Consultation Response from KC, Highways Development Management (HDM)**2021/94280 land at Lady Ann Road, Soothill, Batley, WF17 0PY****Erection of 65 dwellings with associated works****Date Responded: 05/02/24****Responding Officer: A Darwin****Responding Ref: HDC 13-10NE/14****RECOMMENDATION:****No objection, subject to conditions and S106 requirements****Development Overview:**

This is a full Planning Application for the development of 65 residential dwellings on land to the west of Lady Ann Road, Soothill, Batley, WF17 0PY. The site is allocated in the Local Plan (Site HS74) for residential development, with an indicative capacity of 97 dwellings.

Site Layout Plan - Adoptable Highway

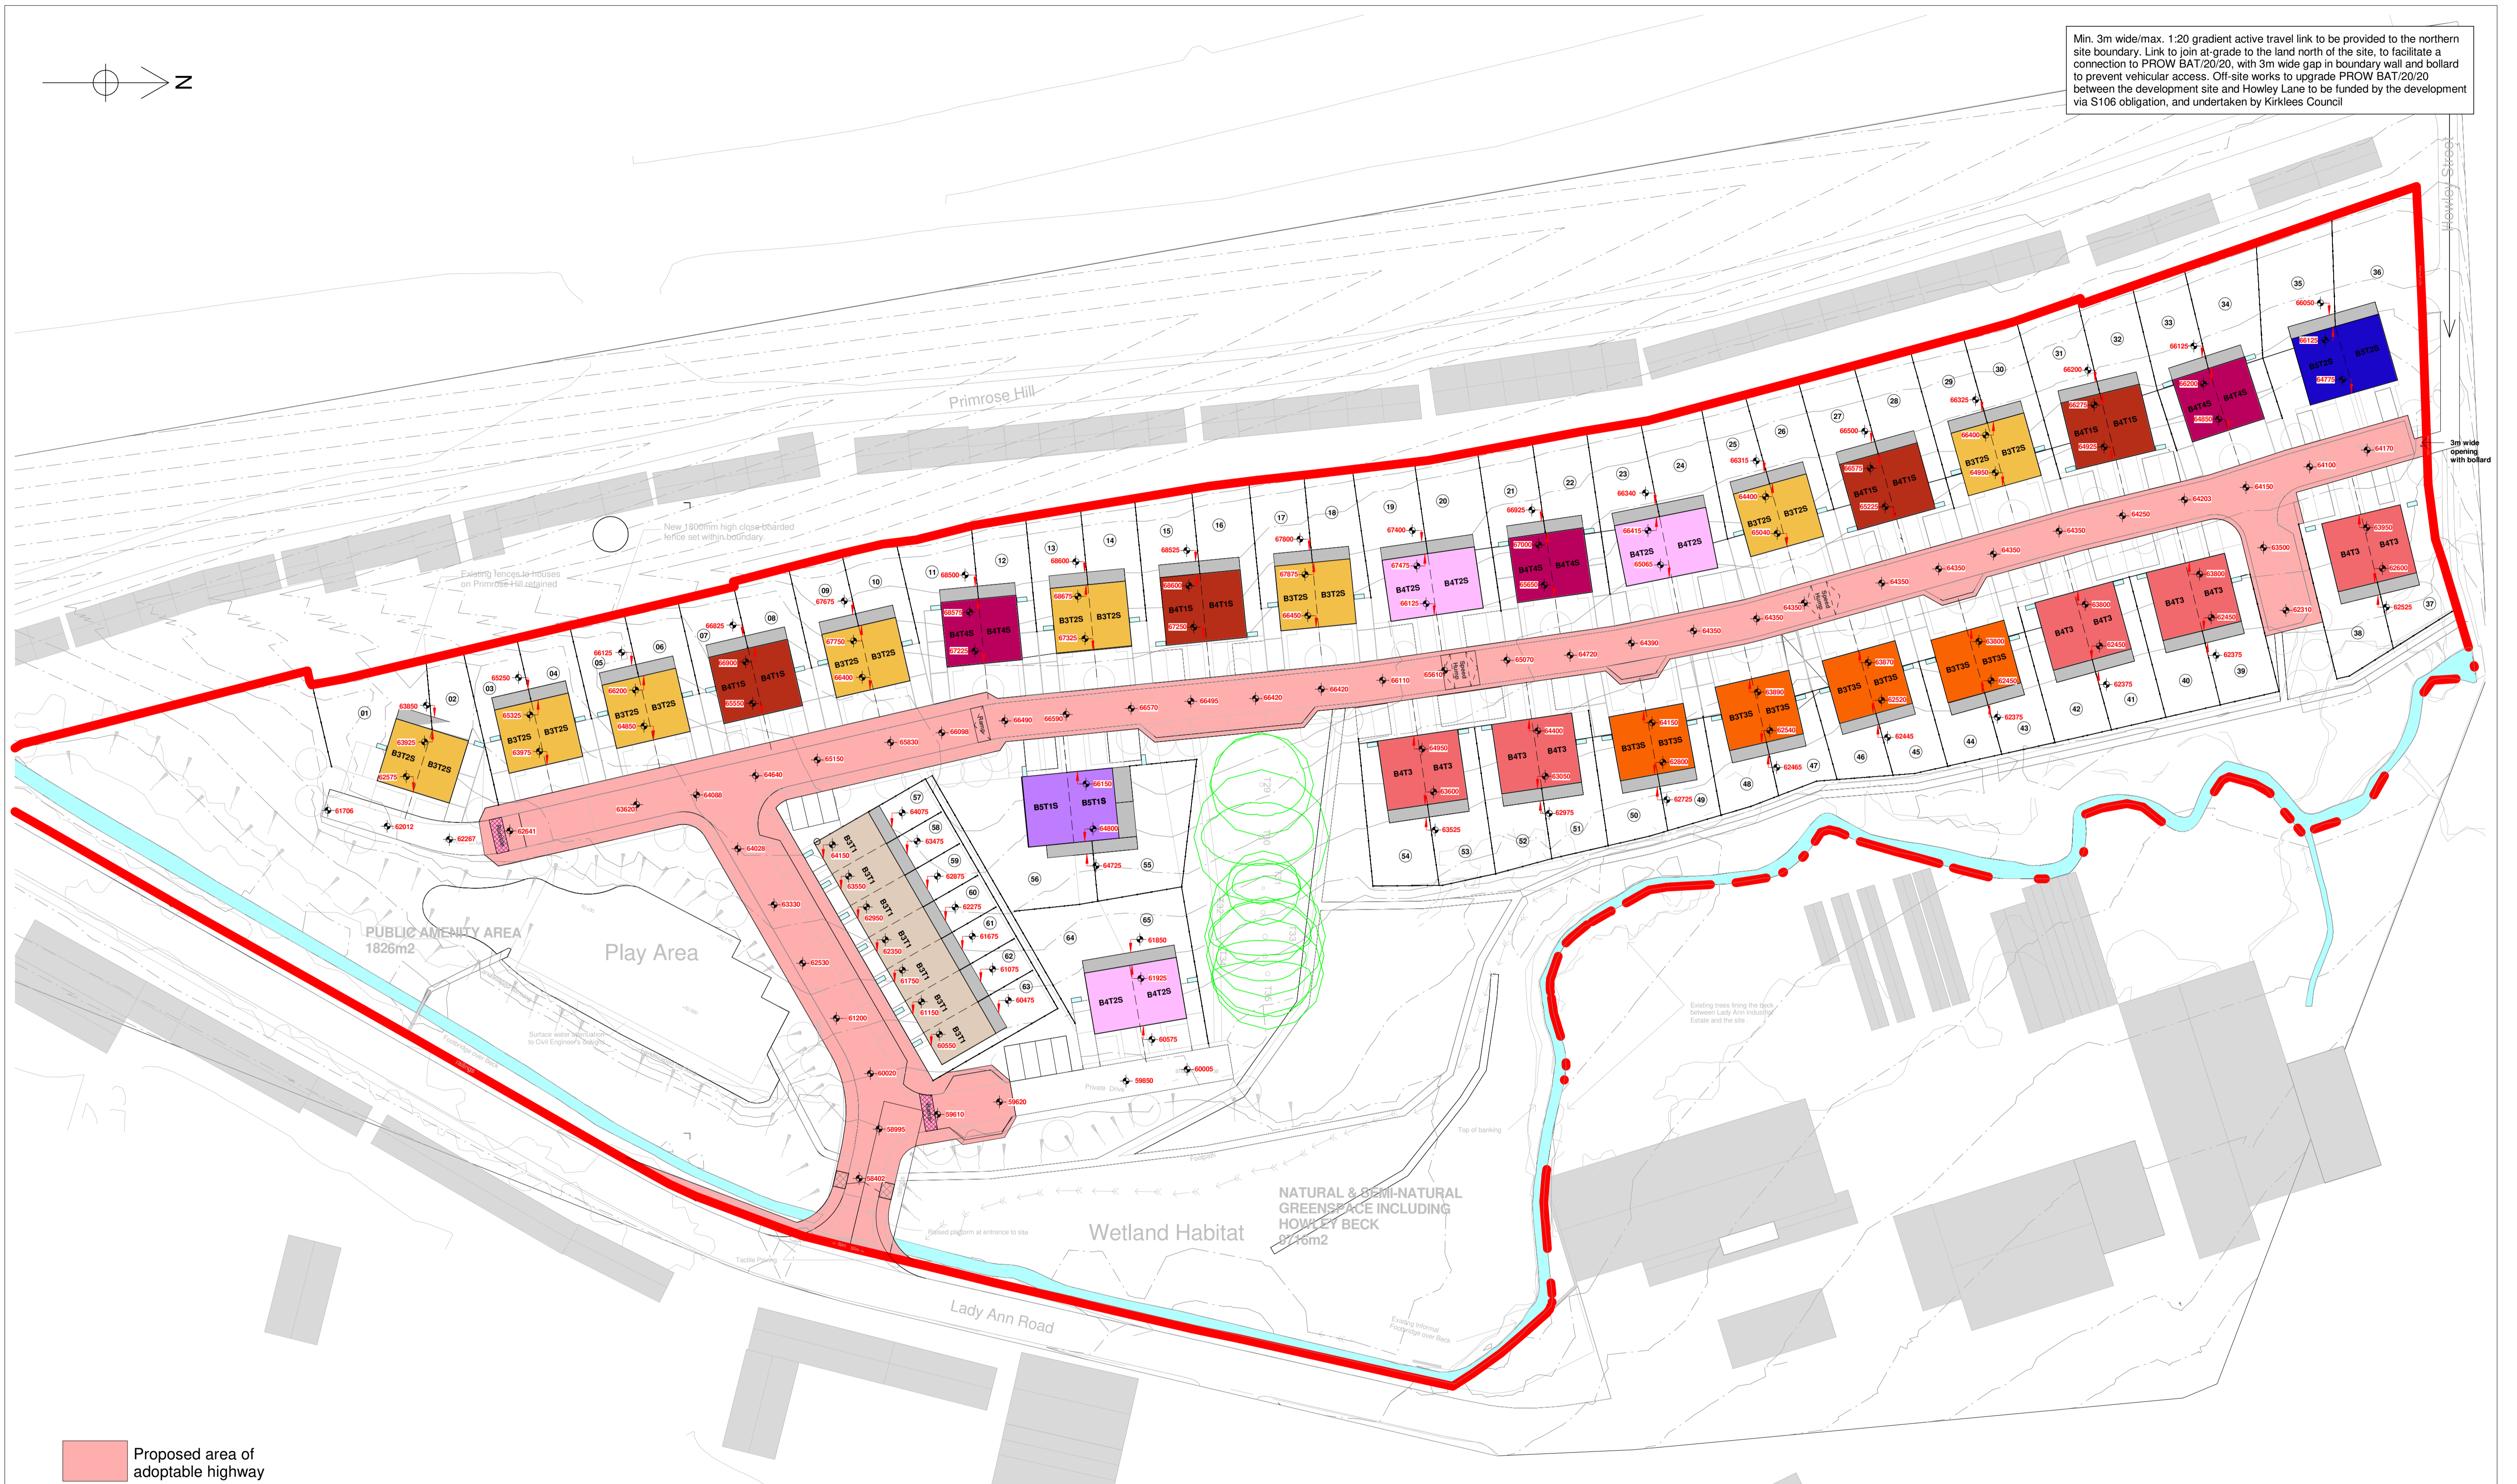
Following lengthy discussions with the applicant, an acceptable site layout has been agreed. The layout includes a traditional estate road arrangement for the initial section (5.5m wide carriageway, with 2m wide footways), which then transitions to a shared surface street (5.5m wide shared surface with 0.6m wide margins). All of the proposed highways have a maximum gradient of 1:20, and include the necessary junction and forward visibility splays contained within the highway boundary. Swept Path Analysis (SPA) has also been provided of the Councils Design Refuse Vehicle, which confirms that all junctions and turning heads are adequate.

The site layout has been subject to a Stage 1 Road Safety Audit, which has not identified any issues that cannot be addressed at the detailed design stage. One issue that was raised was the length and alignment of the shared surface street, which may encourage higher traffic speeds. However, traffic calming features have been proposed along the street, to ensure that a low design speed is achieved. The final detail of the traffic calming features will need to be agreed at the detailed design stage with the Council Section 38 team, but have been indicatively shown as speed humps/tables (although buildouts may be used instead). These traffic calming features have been suitably located to achieve an acceptable design speed, and have been demonstrated as being feasible without impacting private drives/parking areas.

As requested by the Councils PROW Team, the applicant has agreed to provide a 3m wide active travel link within the site, which will connect the end of the proposed estate road to the site boundary. This will then allow the PROW team to progress improvements beyond the site to complete the link to the adjacent public footpath BAT/20/20. The applicant has also agreed to provide a financial contribution of **£10,000** via a Section 106 obligation to enable the Council to complete the off-site PROW improvements to PROW BAT/20/20 that are required to facilitate the link. The contribution would be utilised to fund any necessary legal & staff costs and the physical works. In addition to the financial contribution, the S106 agreement must also secure the following matters to facilitate deliver of the PROW link:

- Ensure that a min. 3m wide / max. 1:20 gradient active travel link is provided along the northern site boundary, to connect the estate roads to BAT/20/20, with the design and specification agreed with the Local Planning Authority.
- The link must join at-grade to the land north of the site boundary, to facilitate the connection to PROW BAT/20/20, with a min. 3m wide gap in the boundary wall and bollard provided to prevent motor-vehicular access.
- The applicant to use all reasonable endeavours to assist the Council in delivering the PROW link.
- The applicant to either dedicate the link as highway (for pedestrians and cyclist use) or ensure that public rights of way are granted over it. This should also apply to the pedestrian/cycle route through the site along the estate roads, although this would be superseded if/when the streets become adopted highway.

PROPOSED SITE PLAN

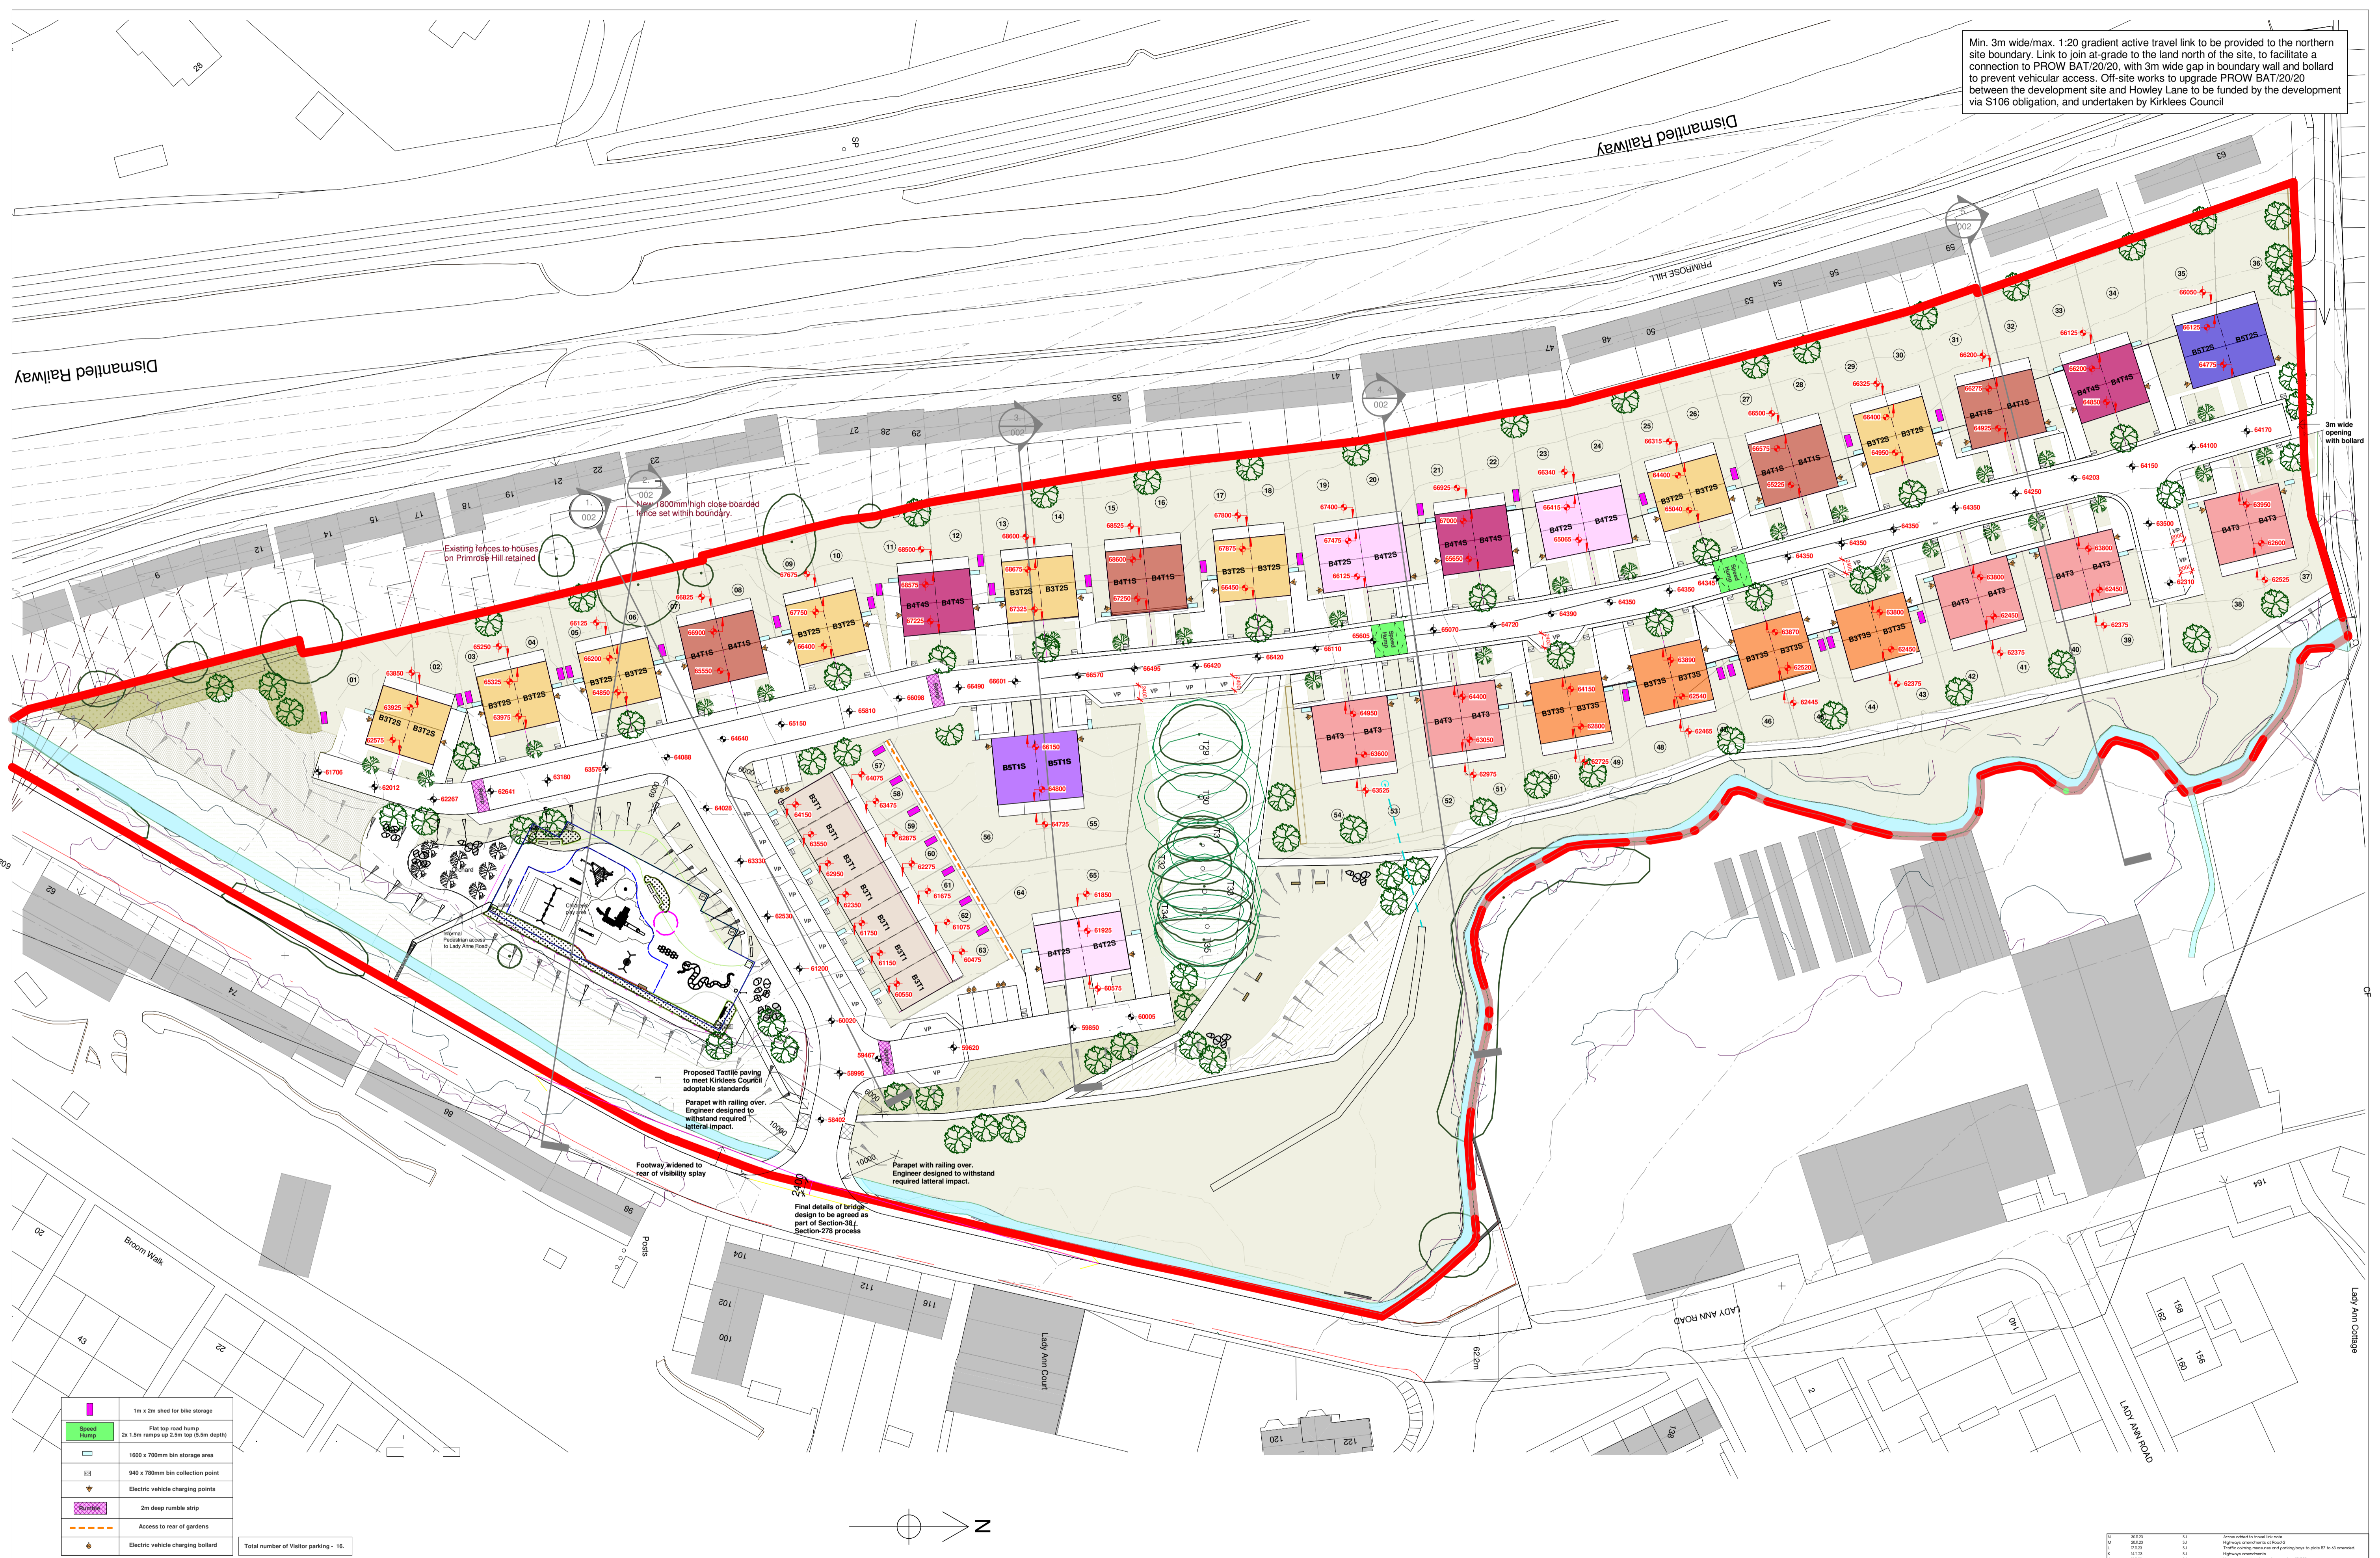
Whilst the majority of dwellings have off-street parking in full accordance with the Kirklees Highway Design Guide SPD, there are 7 No. terraced 3 bedroom dwellings (No.s 57-63) that only benefit from 1 dedicated off-street parking space per dwelling. However, this has been mitigated by providing an 8 space visitor parking layby adjacent to these units, to accommodate any additional parking demand from these properties.

All dwellings will be provided with secure cycle storage, either within their garage, or in a cycle shed located within their garden, as shown on the proposed site layout plan. Whilst the principle of the cycle parking is acceptable, the final details will need to be secured by condition, as only limited details have been provided and the proposed 1x2m cycle sheds appear to be too small to accommodate a full range of cycle types.
